Director, Urban Assessments  
Department of Planning  
GPO Box 39  
Sydney NSW 2001

18 August 2009

**MP08\_0257 – Early Works Package  
61 Mobbs Lane - Epping  
Channel 7 Site (Epping Park)**

A1

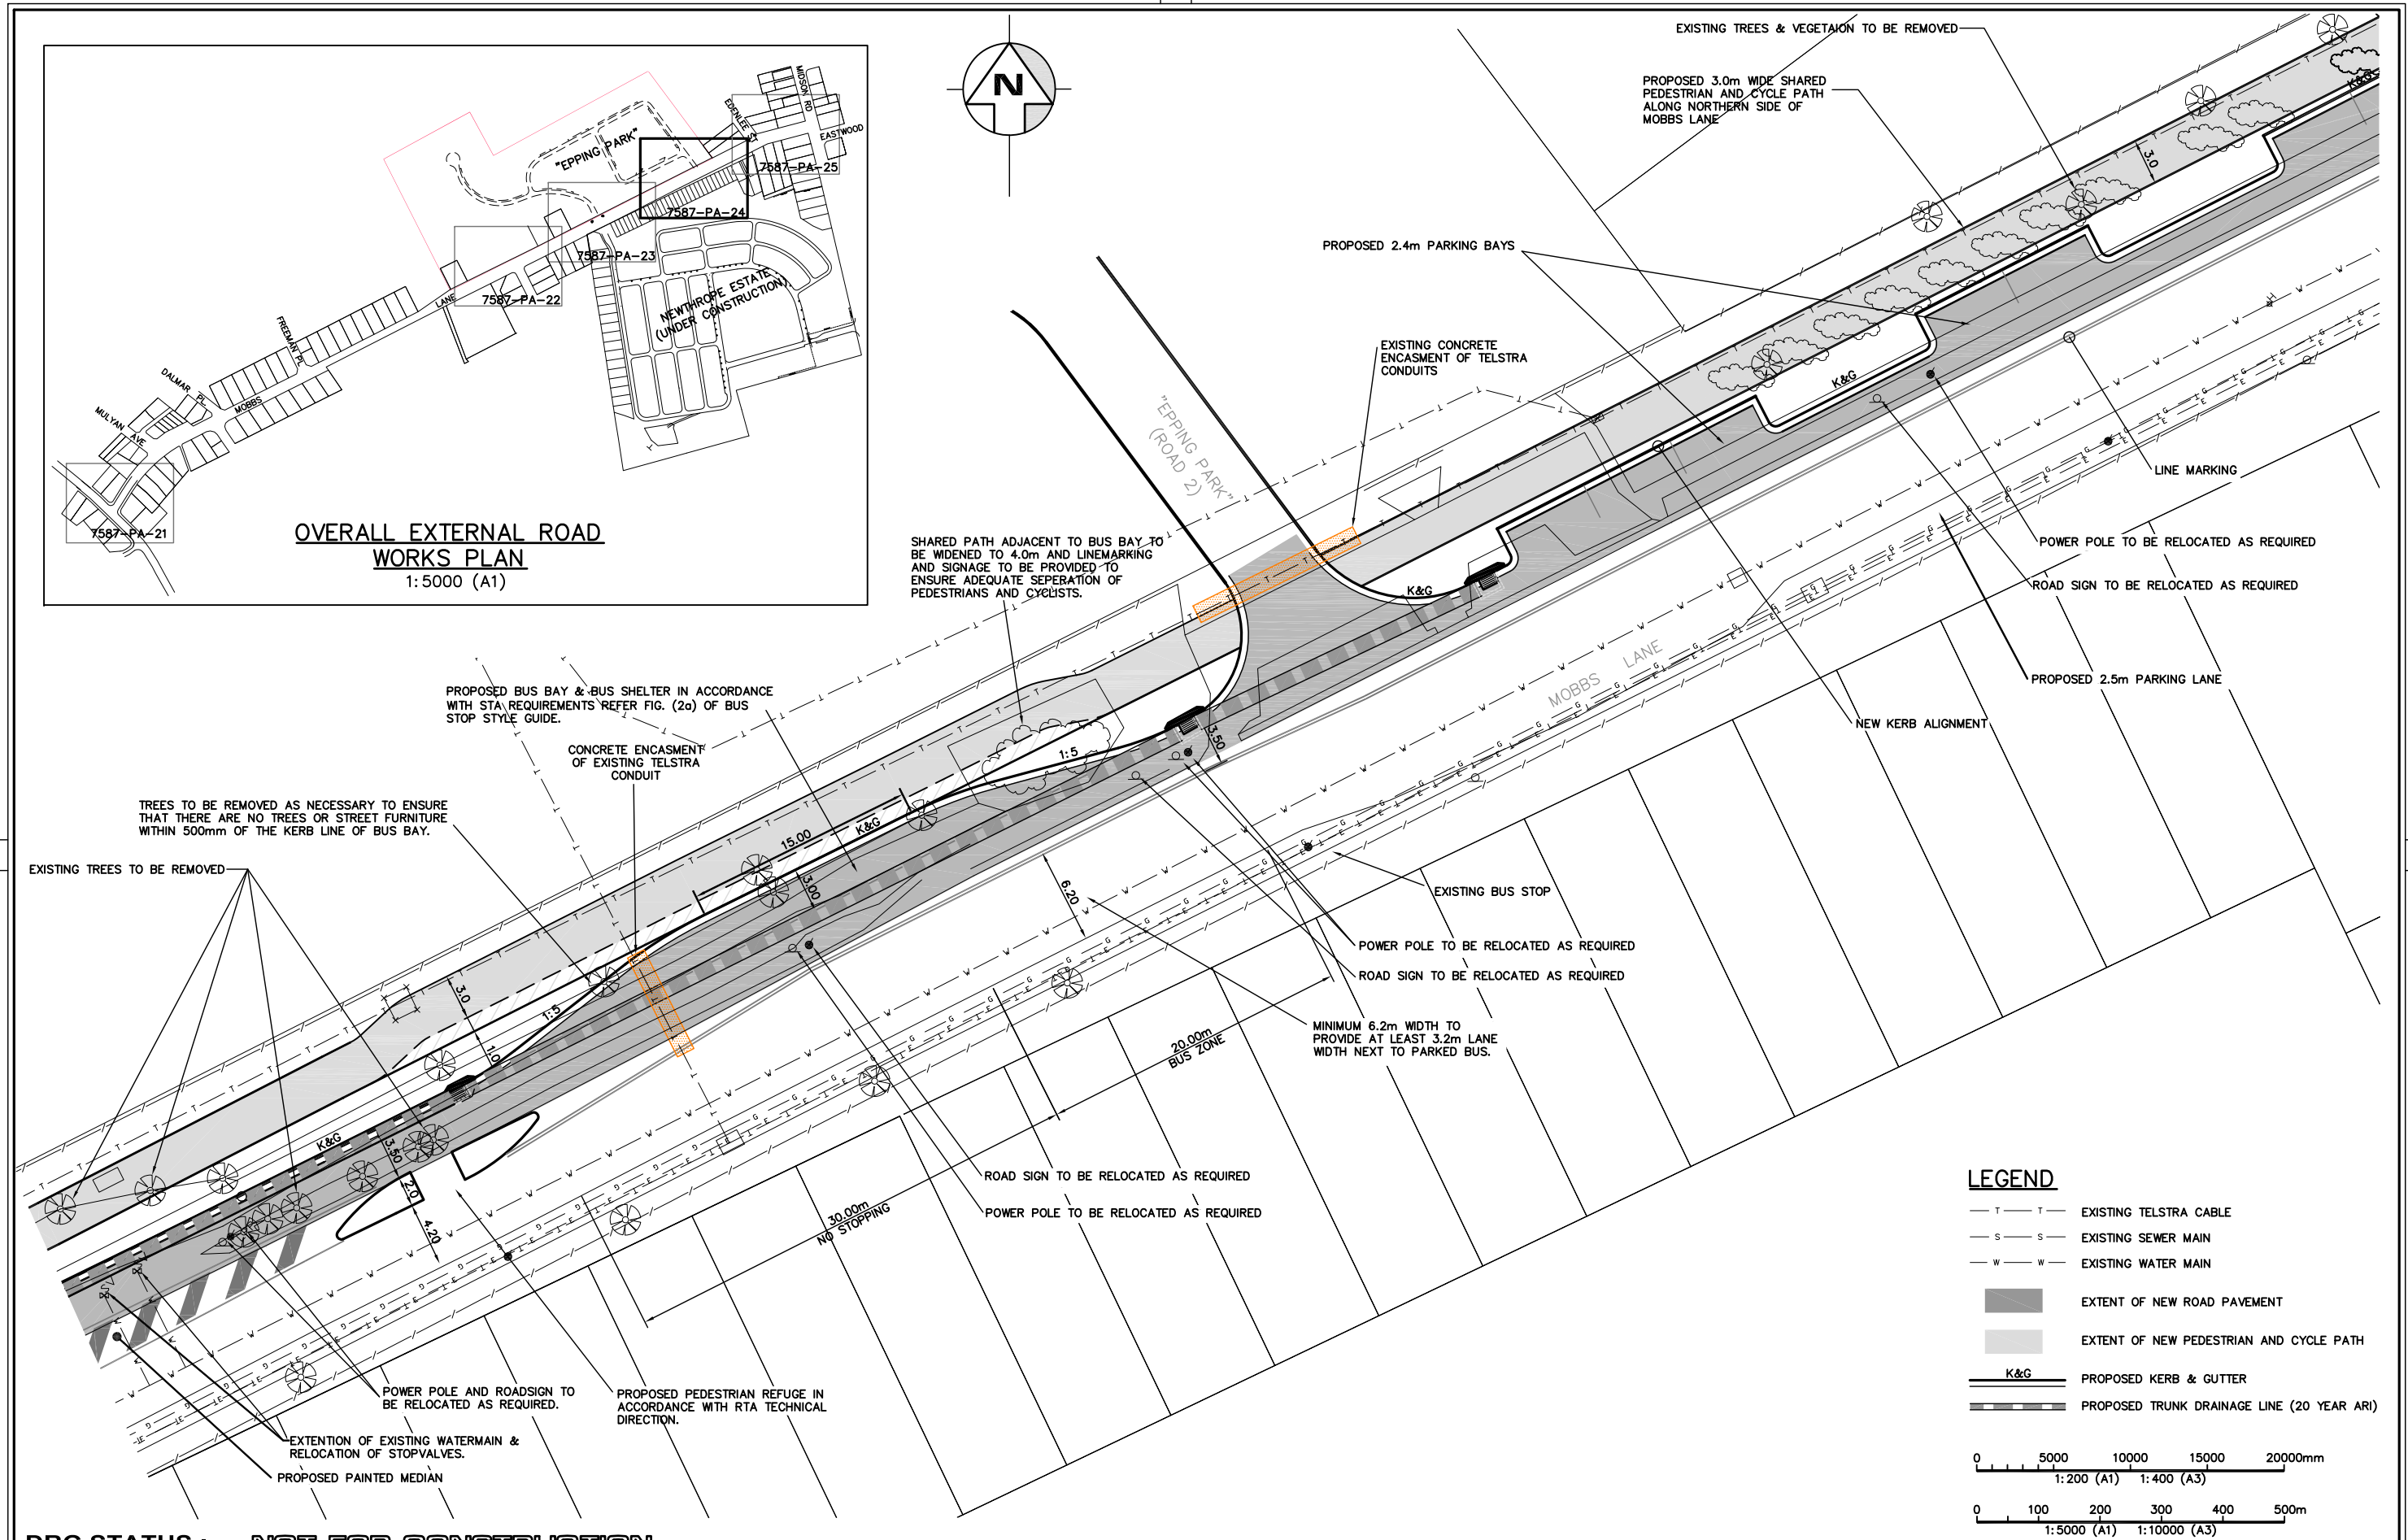
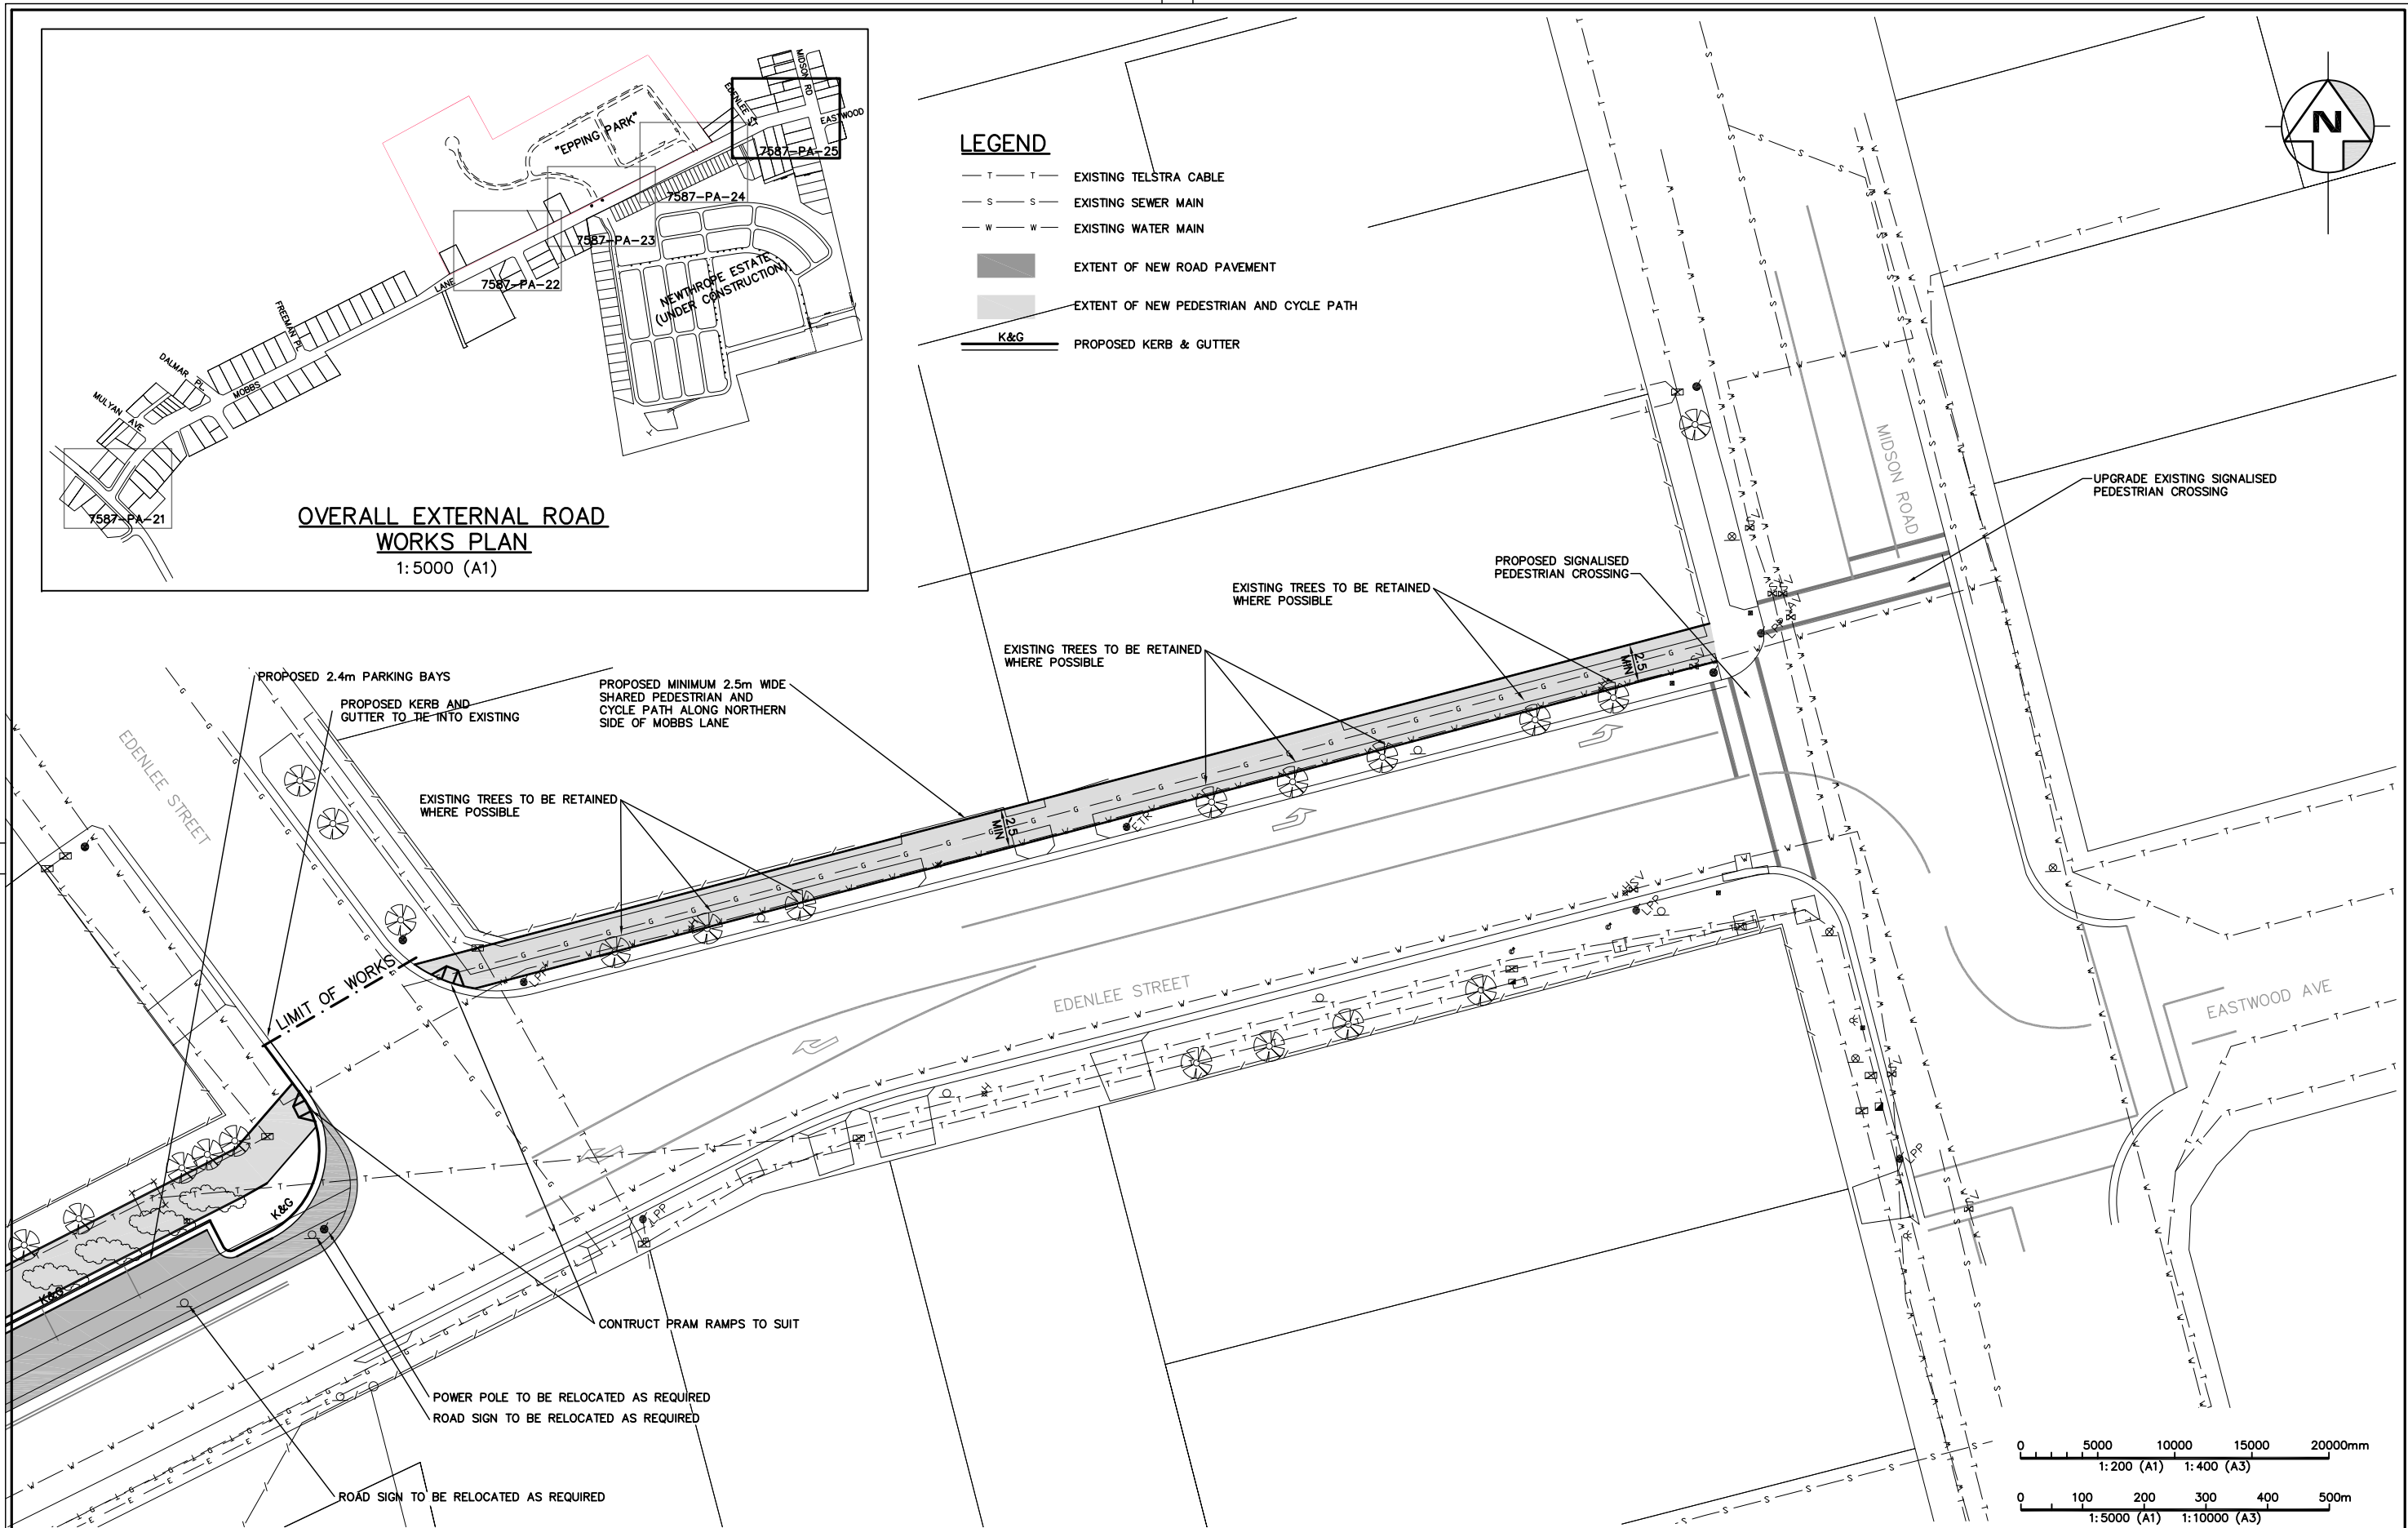
Road design details are to be submitted to Council for approval, including detailed design of the proposed pedestrian refuge island according to RTA requirements & Technical Direction.

On-street parallel parking bays should comply with AS 2890.5 On-Street Parking.

All parking signs associated with the development improvement works should be submitted to Council for approval through Council's Traffic Committee prior to final occupation.
